ENG-P22009-R1-TIS redlines.pdf Markup Summary

Figure 5

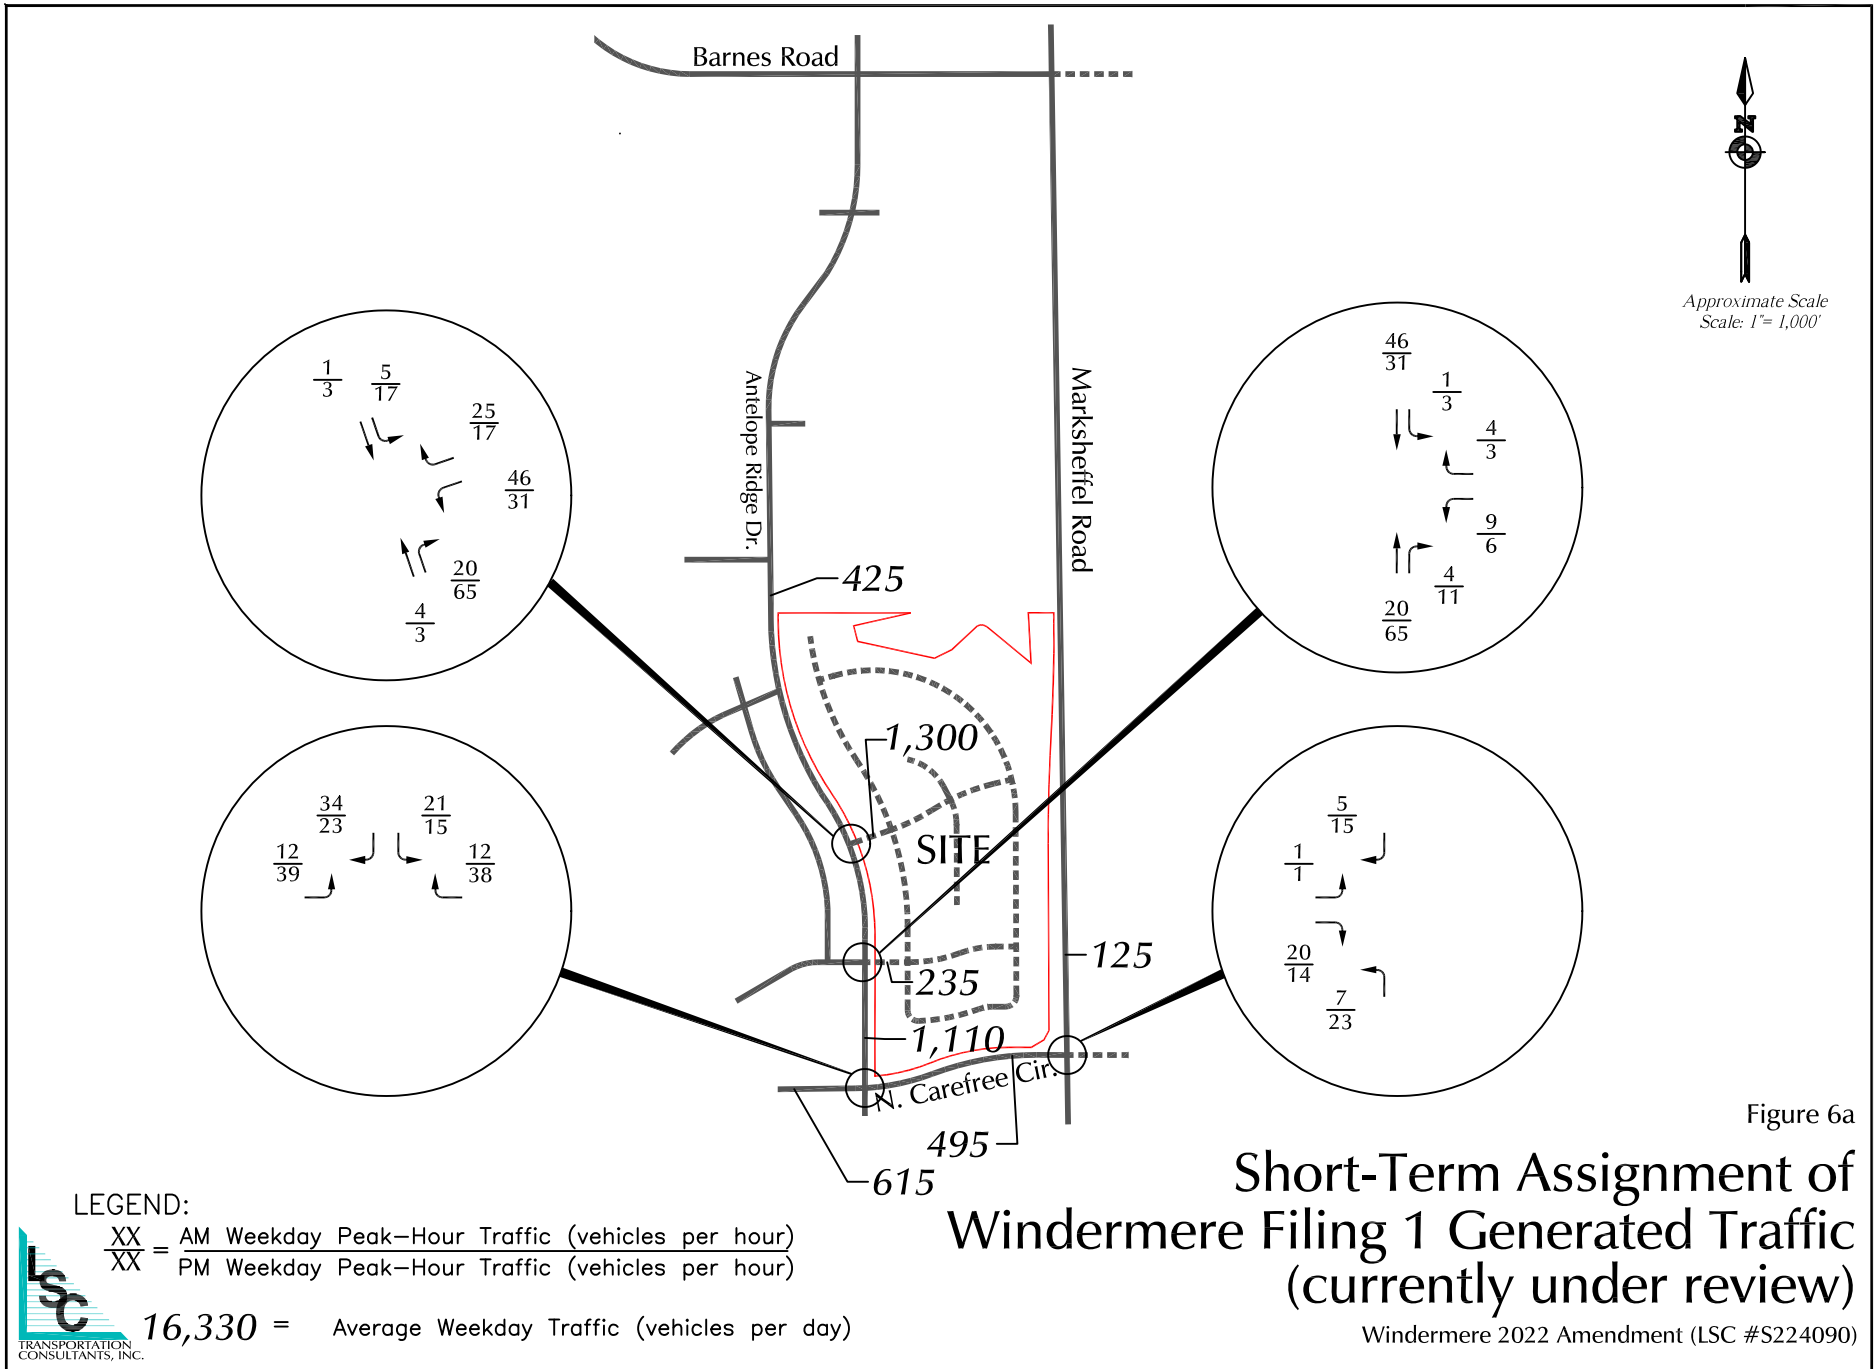
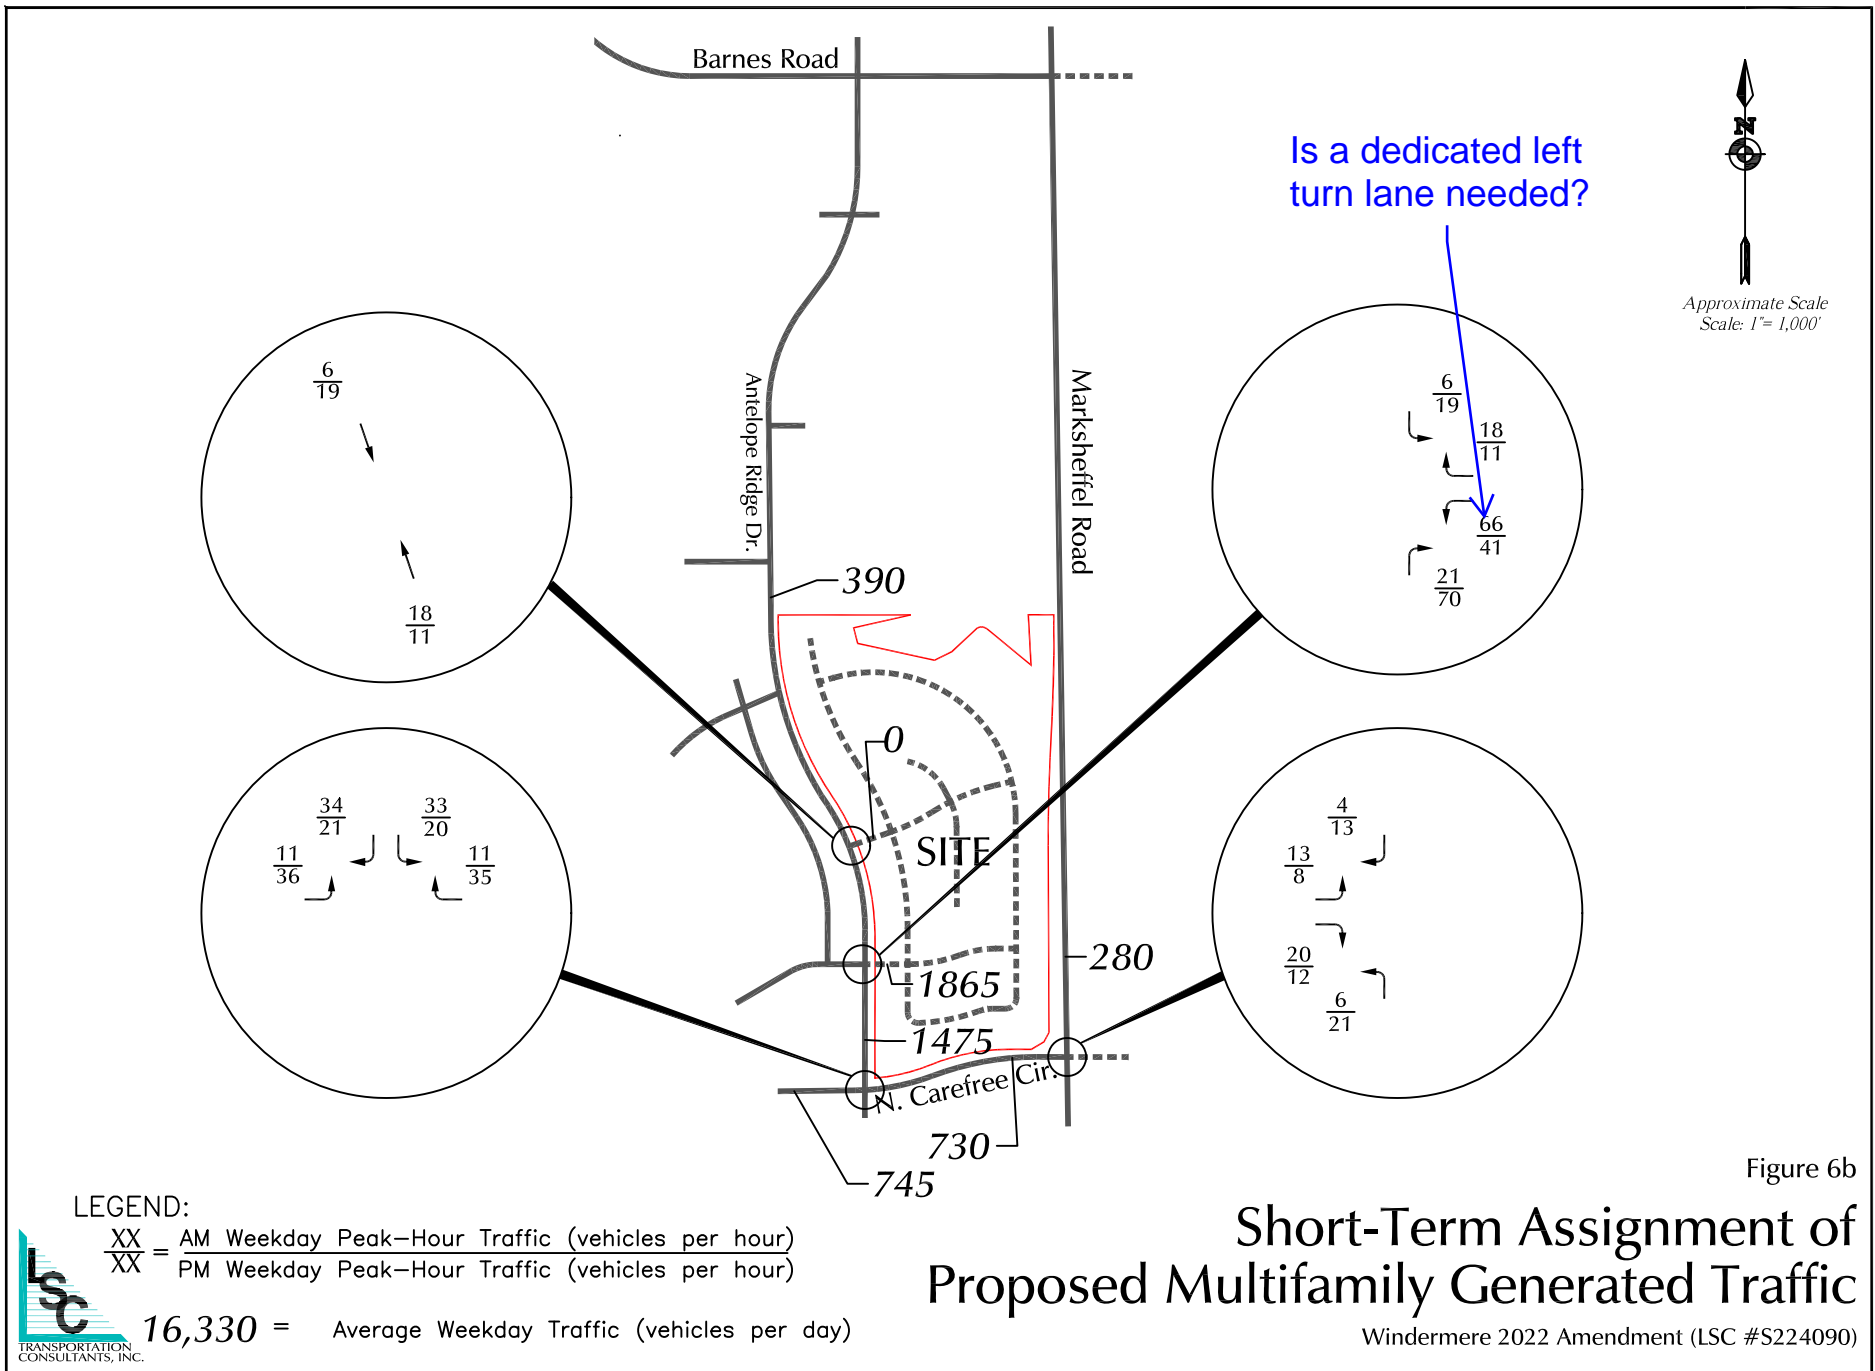
Is a dedicated left turn lane needed?

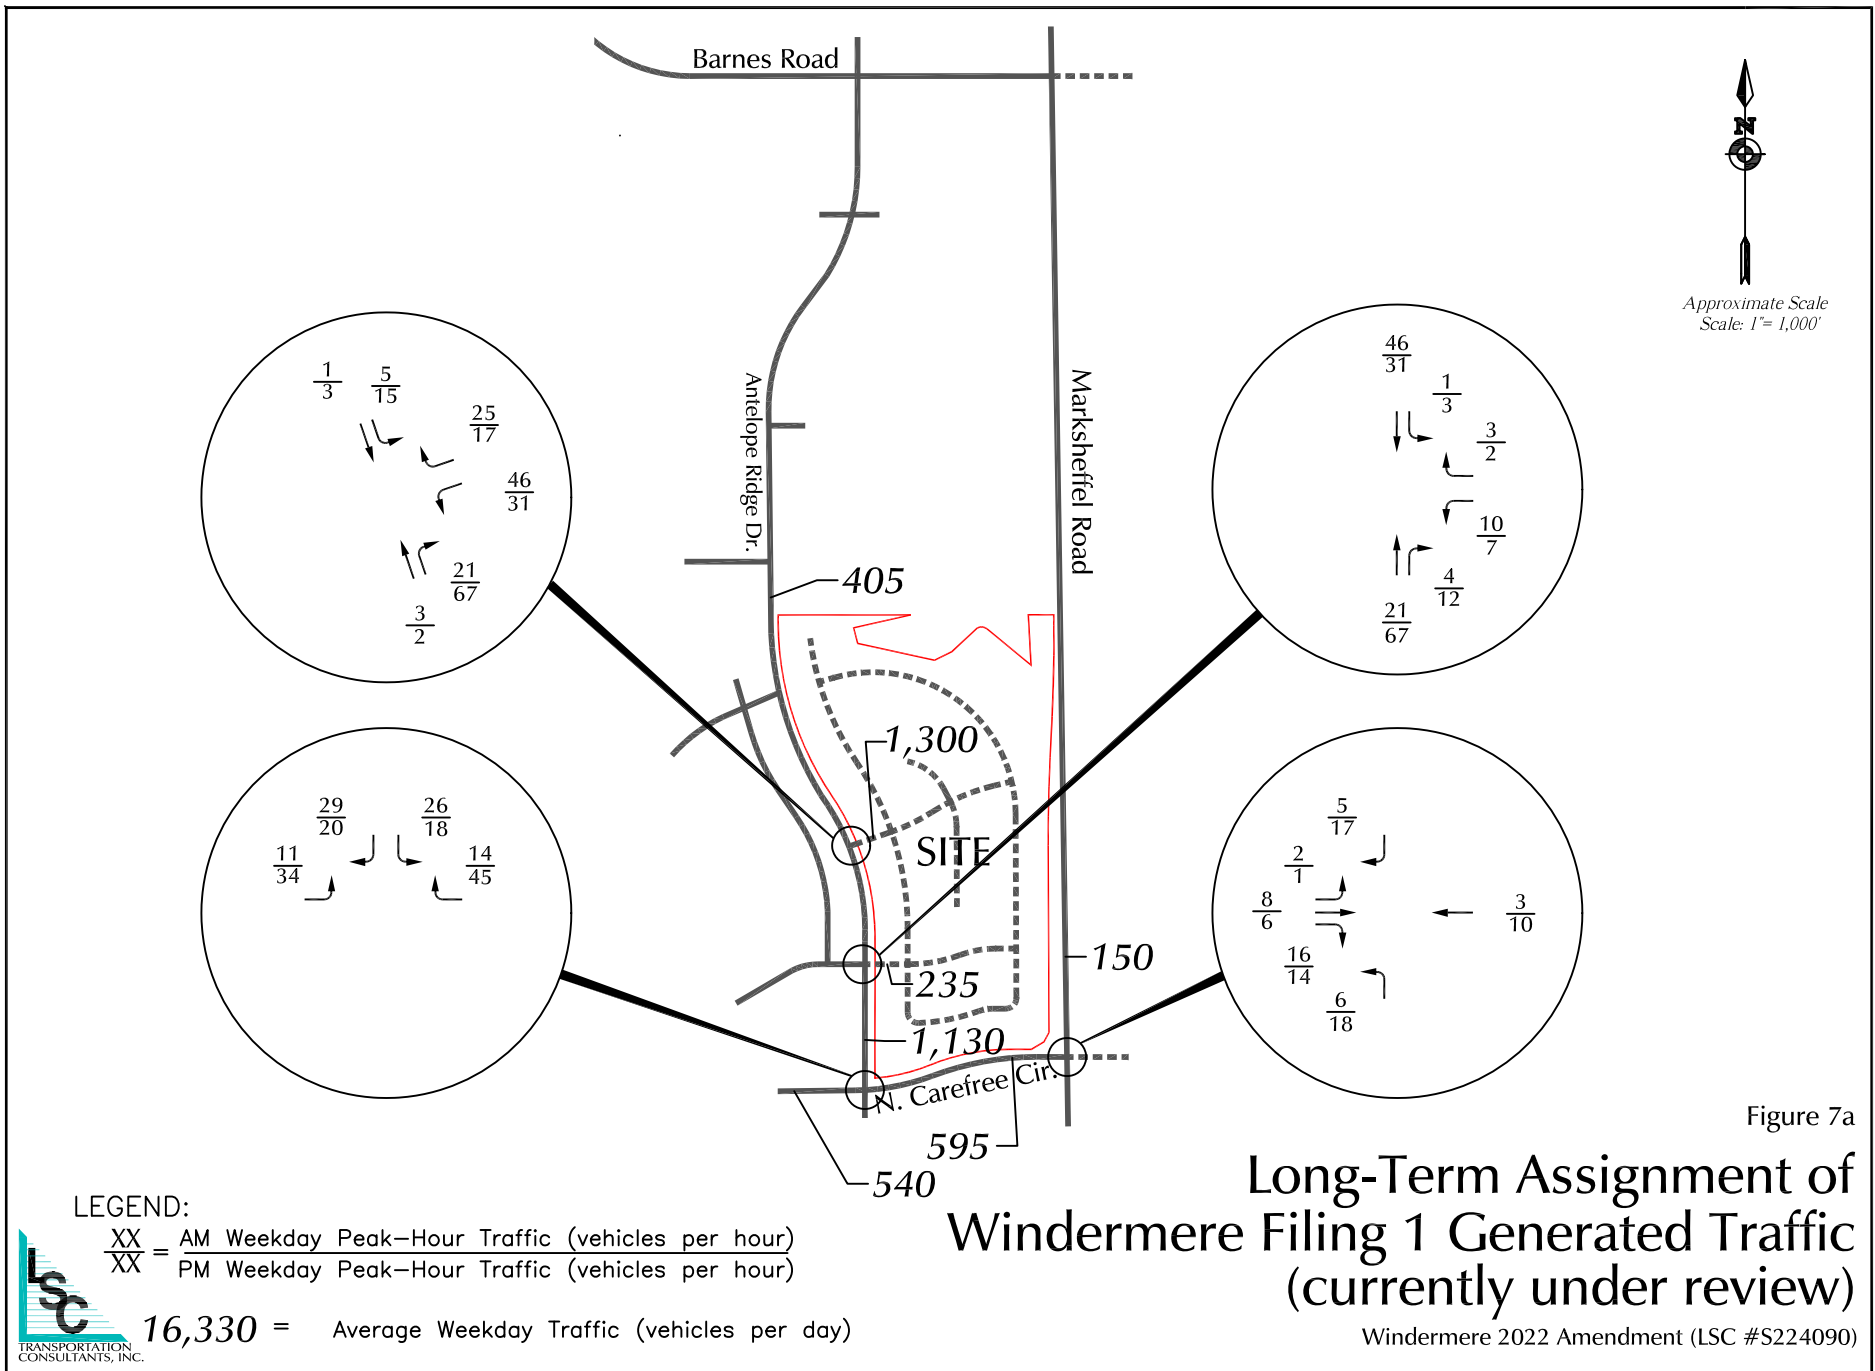
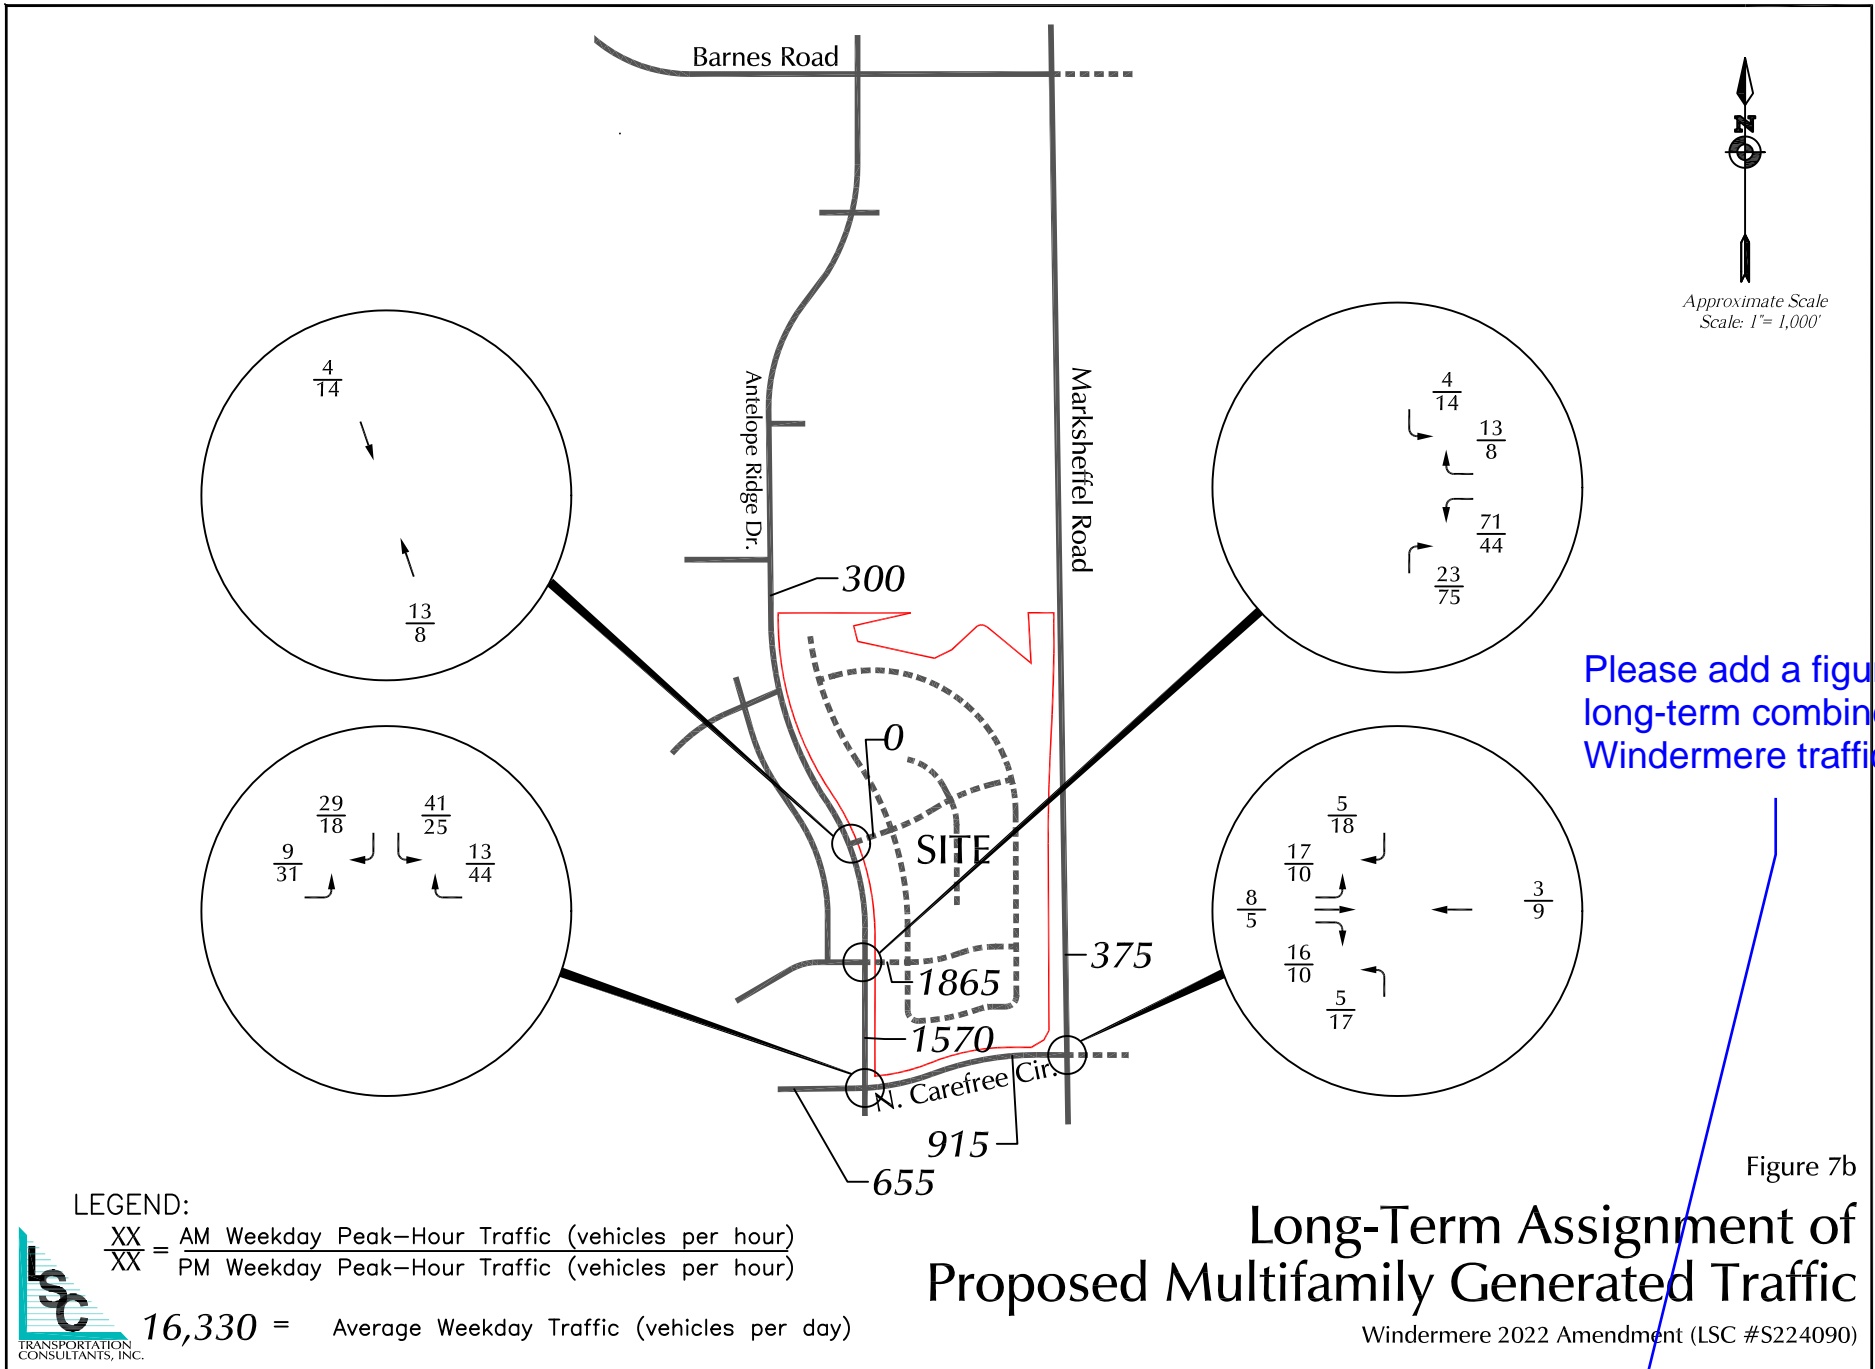
Please add a figure for long-term combined Windermere traffic
